**Our Case Number:** ABP-316178-23

**Re:** Proposed development of Oweninny Windfarm Phase 3 consisting of 18 no. wind turbines.  
Within the townlands of Laghtanvack, Croaghaun (also known as Croaghaun West), Moneynieran,  
Corvoderry, Shanvolahan, Dooleg More, Shranakilly, Bellacorrick and Shanvodinnaun, Co. Mayo.

11<sup>th</sup> November 2023

Re: Proposed development of Oweninny Windfarm Phase 3 consisting of 18 no. wind turbines. Within the townlands of Laghtanvack, Croaghaun (also known as Croaghaun West), Moneynieran, Corvoderry, Shanvolahan, Dooleeg More, Shranakilly, Bellacorick and Shanvodinnaun, Co. Mayo.

Drawing file: EIAR Appendix 15.4 Photomontages / VP9 Local Road at Formoyle.pdf

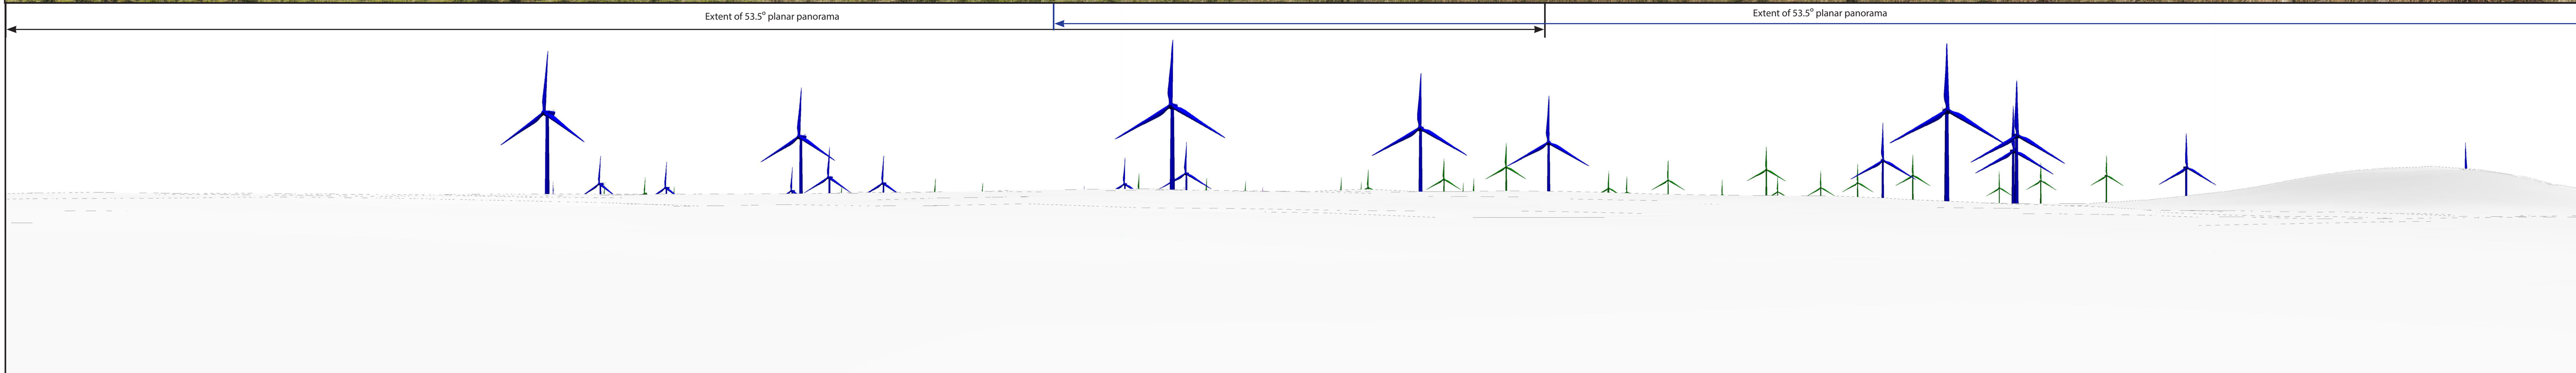
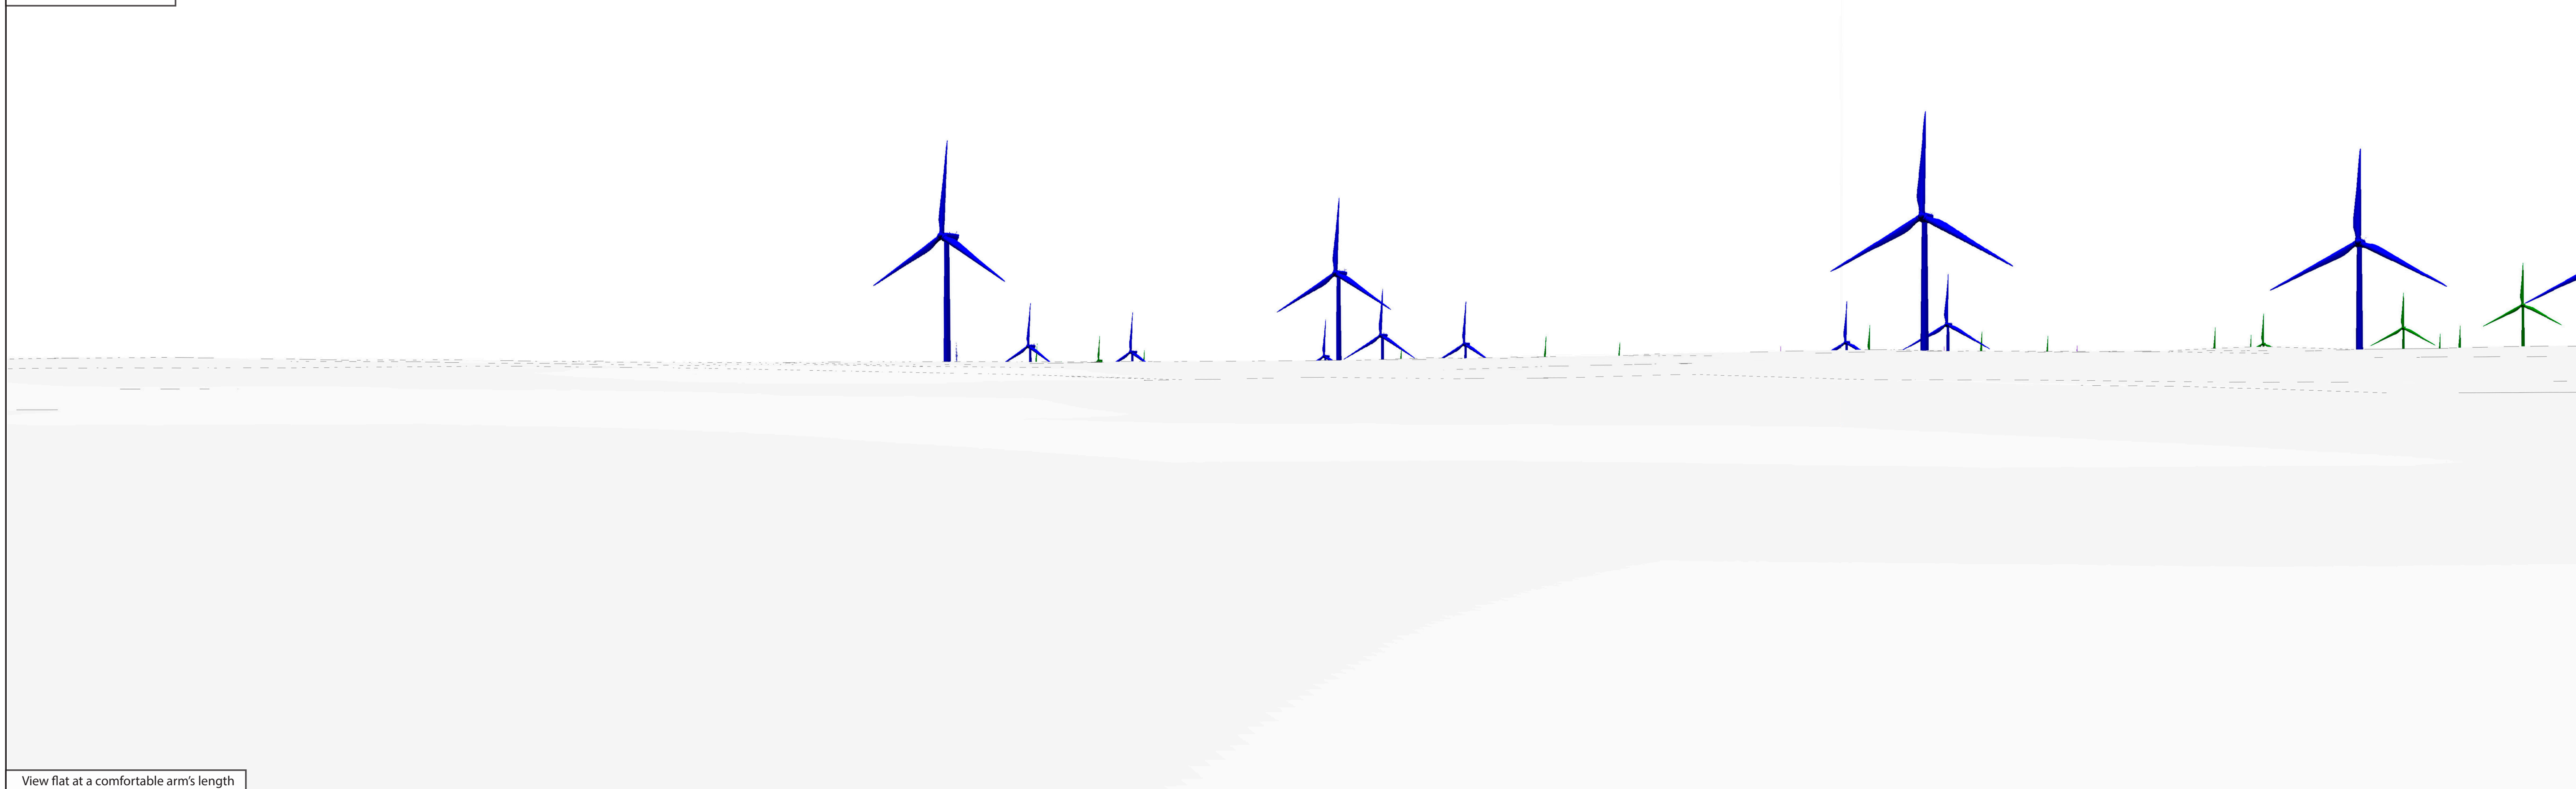
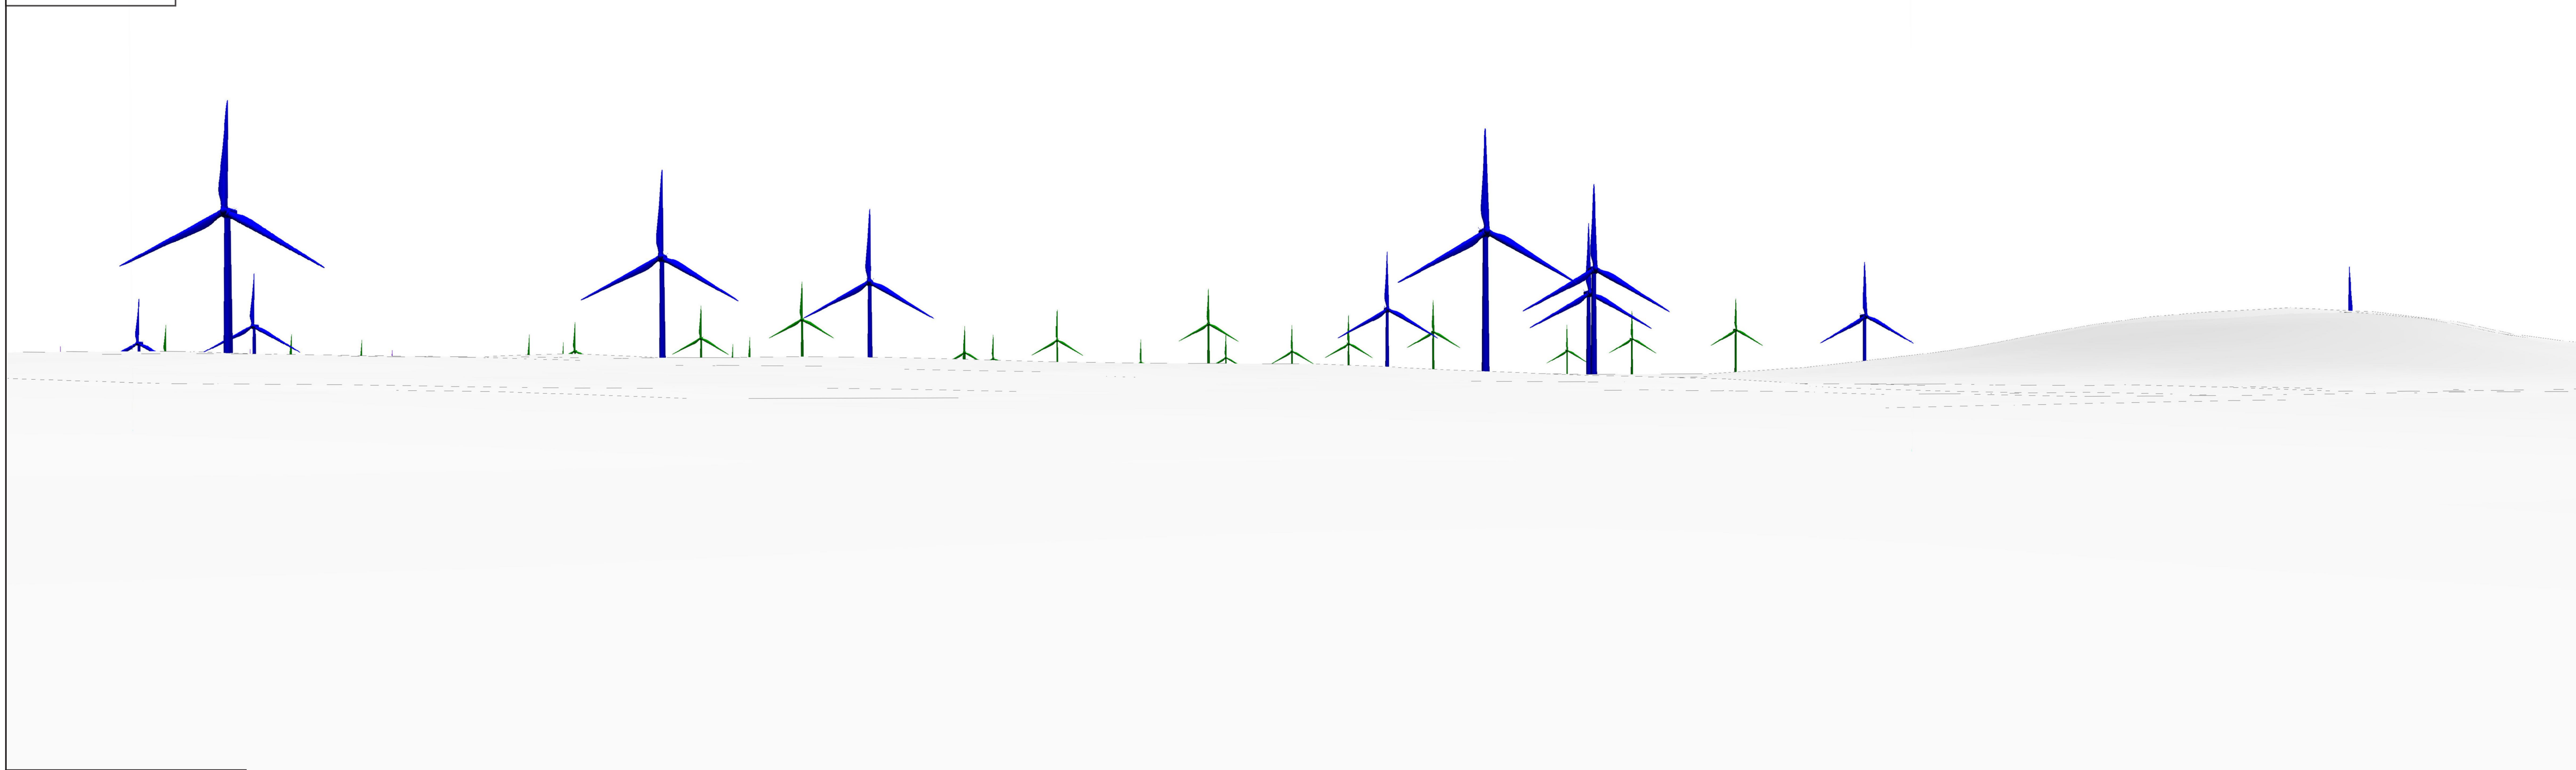
What is very clear from the photomontage offered from the nearest viewpoint (VP9) is that these turbines will indeed be spatially dominant and overbearing within views from our farm and property. This is in complete contrast to applicants response.

Again I would ask the board to view the photomontage provided from their nearest viewpoint to our property (VP9). The impact which the planned turbines would have on our property are obvious. We have had a local property valuer out to determine the current value versus the potential value if the applicant is successful. Due to the uniqueness of our site and property, it has been determined that our farm and property will be devalued substantially by a six figure sum due to the close proximity and impact of these turbines. This valuation can be made available to ABP on request, we also welcome any other independent valuations that the board or applicant may request.
